# THE RESERVE AT CORRAL BLUFFS SUBDIVISION

## Construction Drawings

### El Paso County, Colorado

**C1**

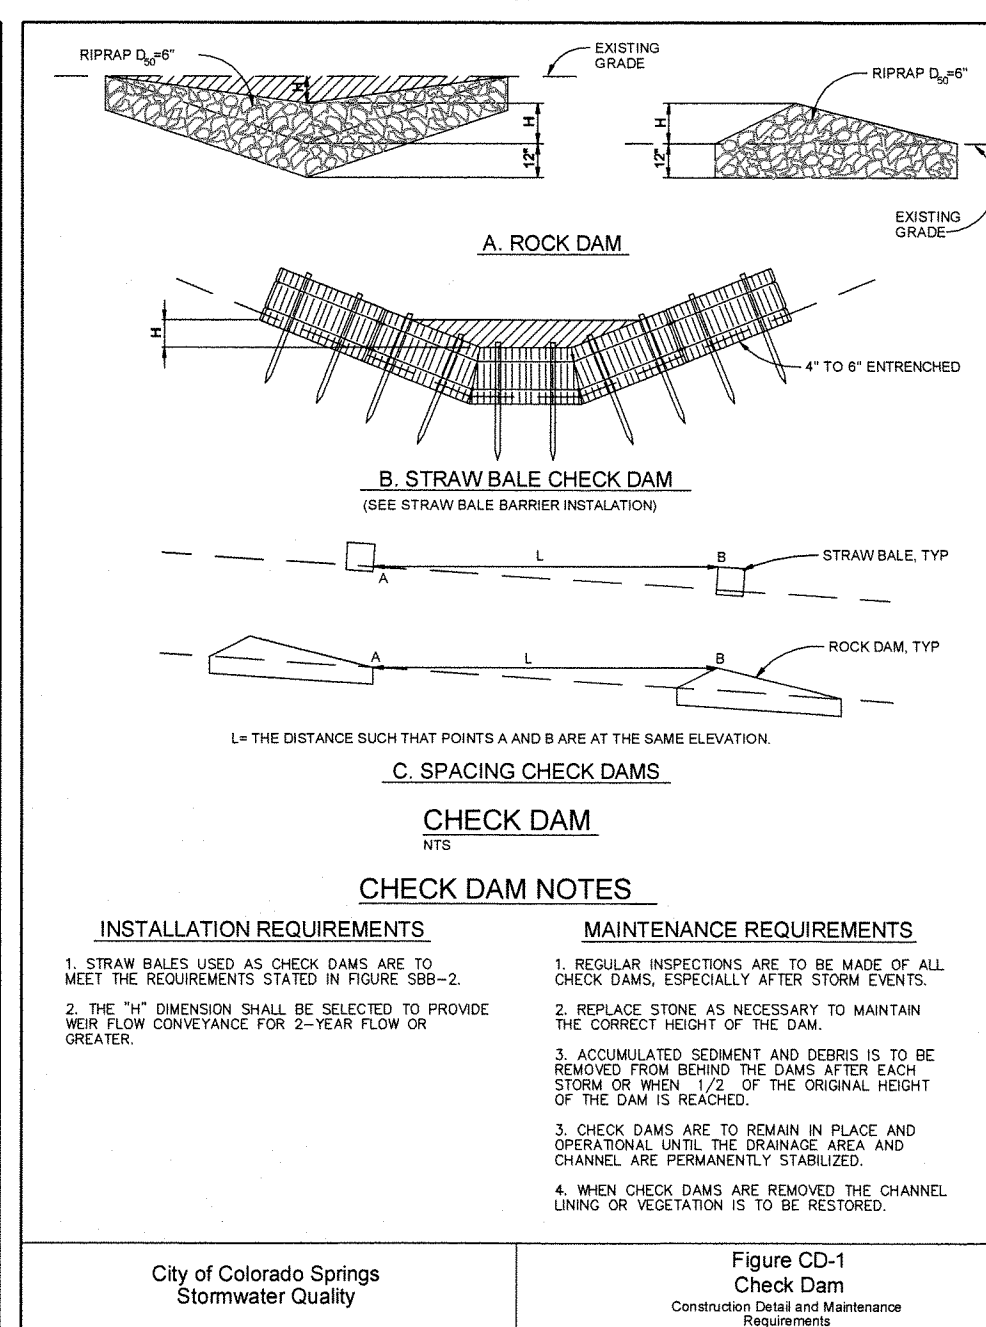
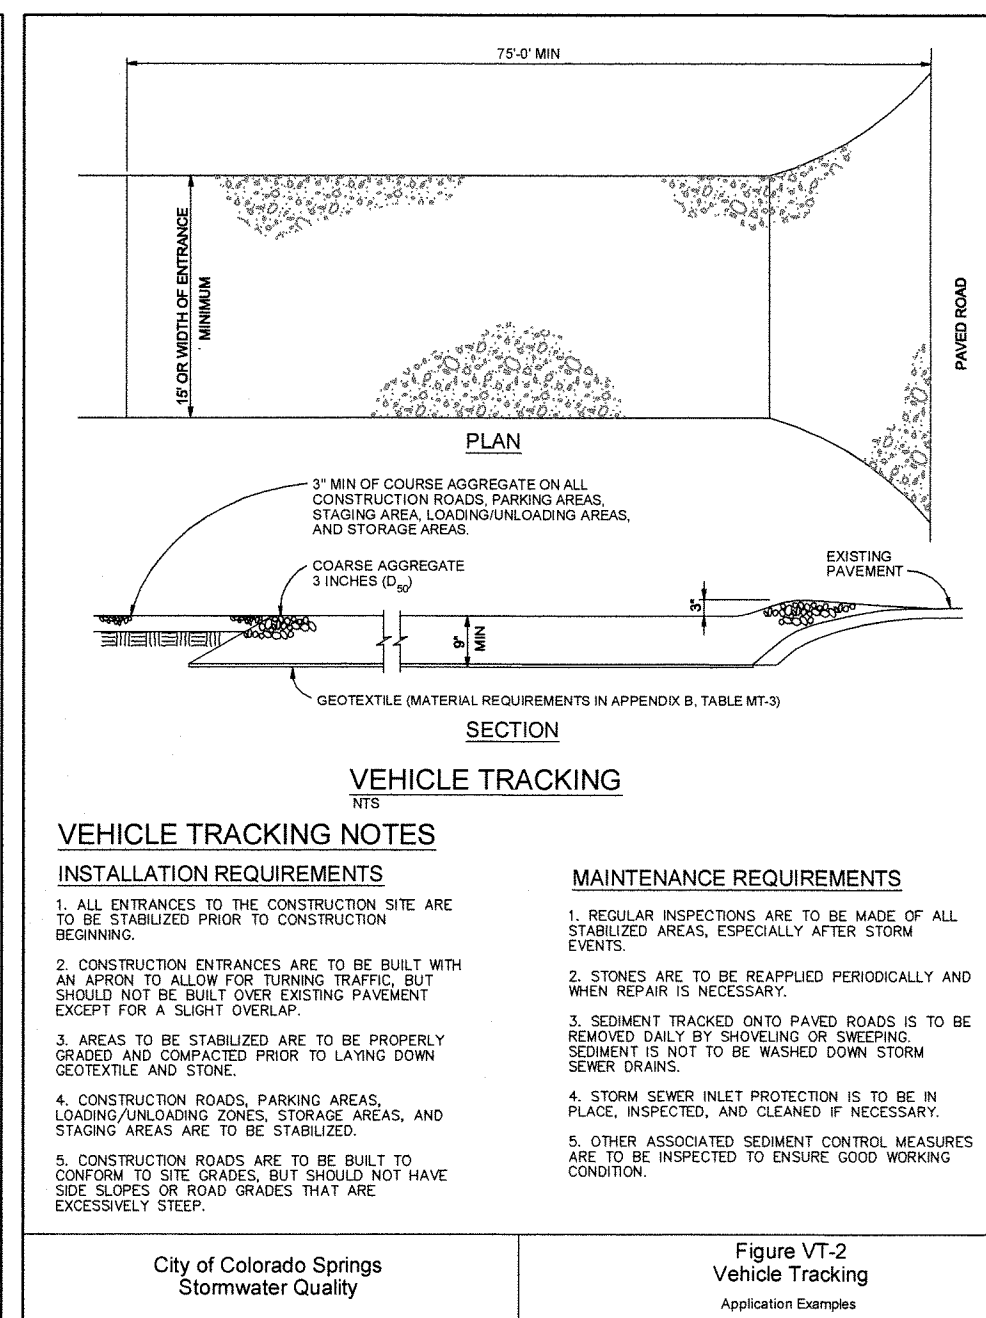
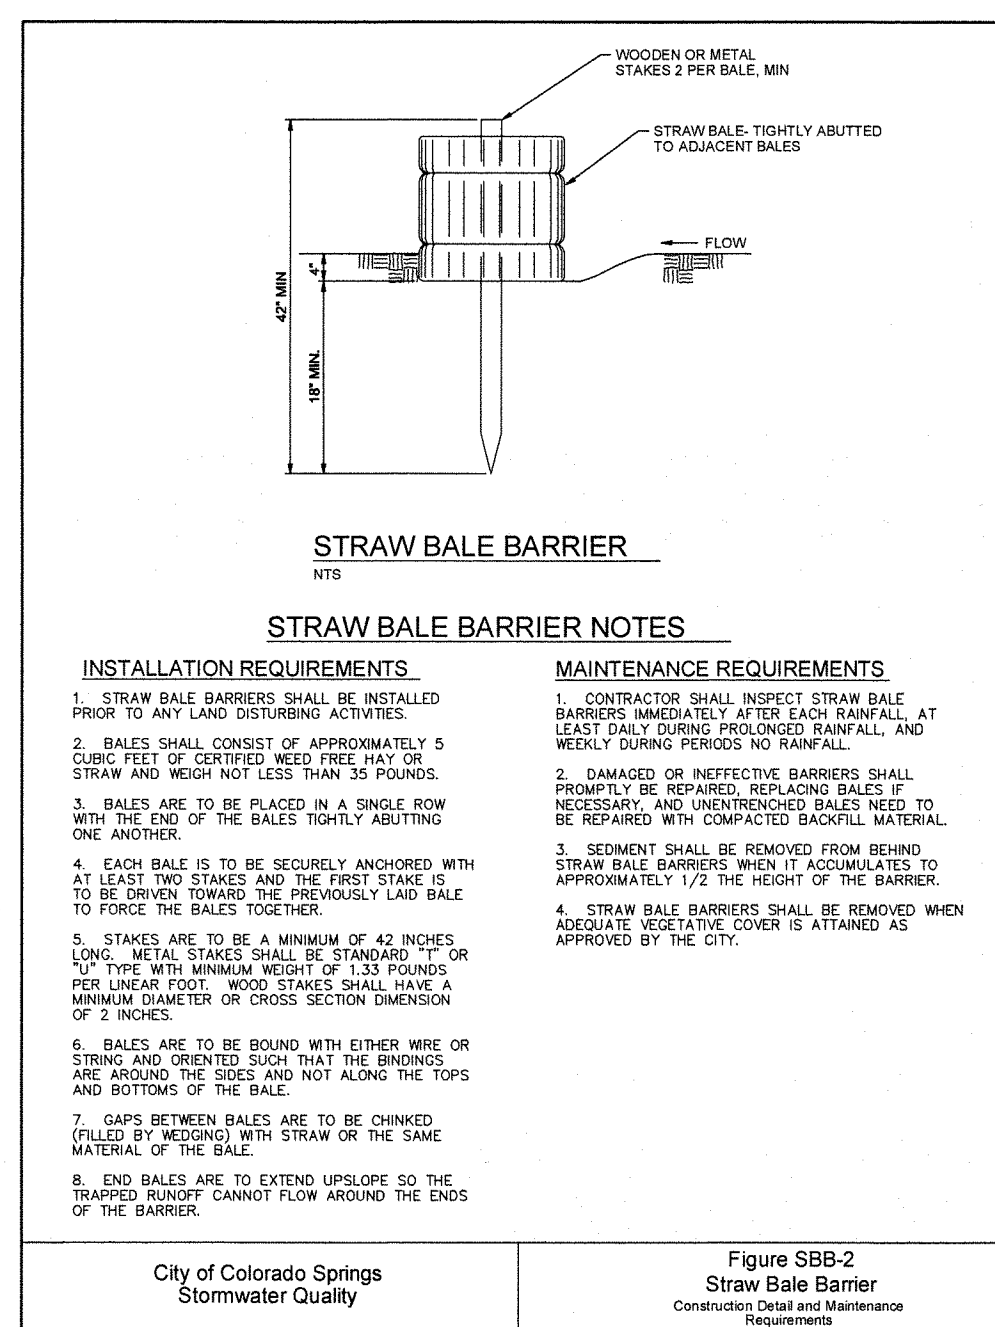
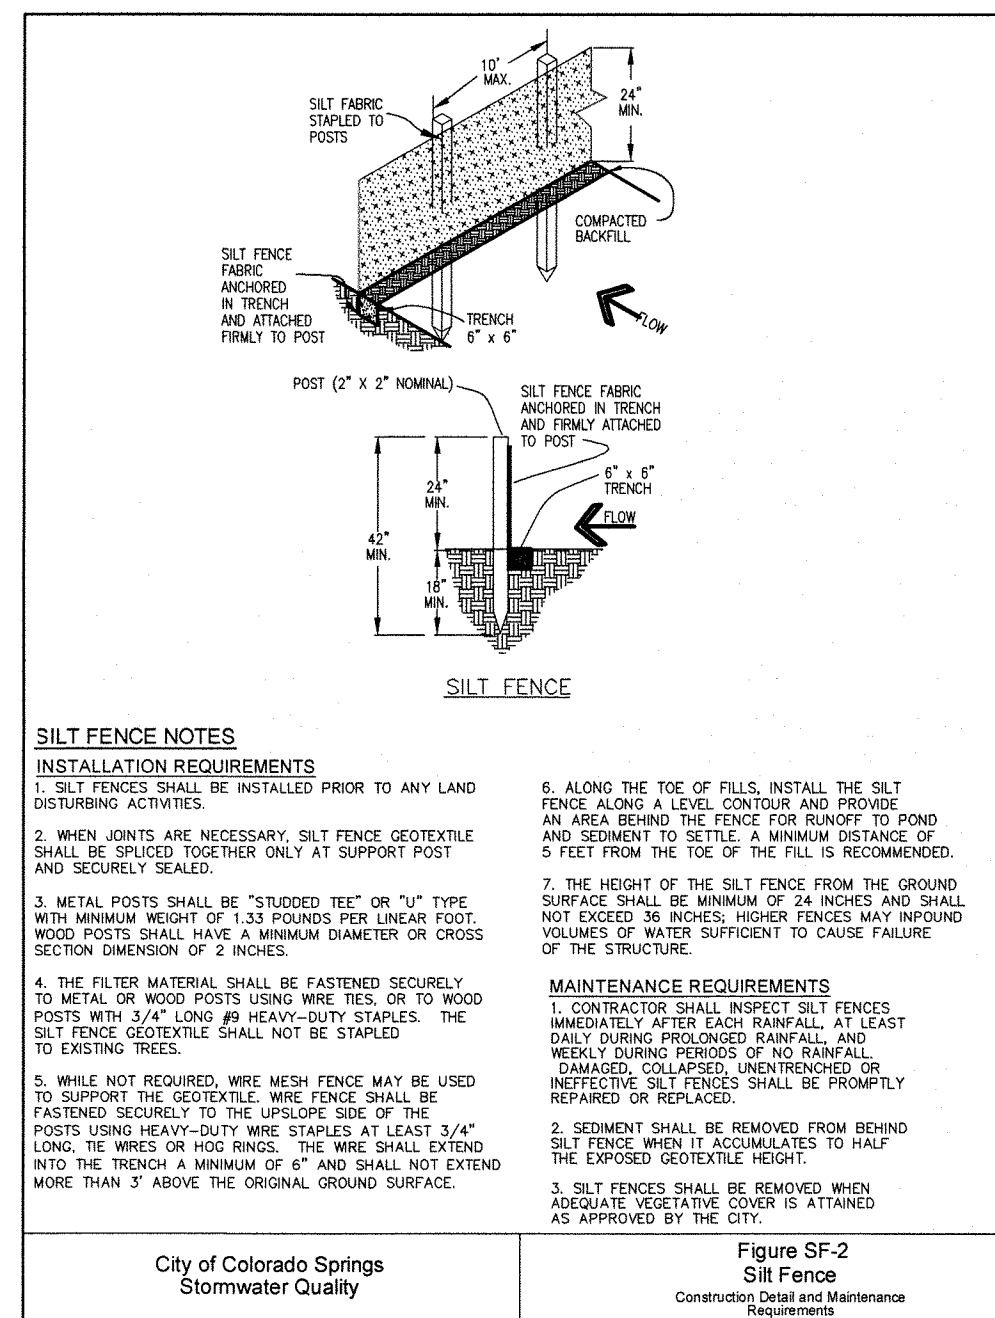
Update the GEC to show VTC at the entrance to Filing 2 and the removal of the temp cul-de-sac.

Identify the inlet protection
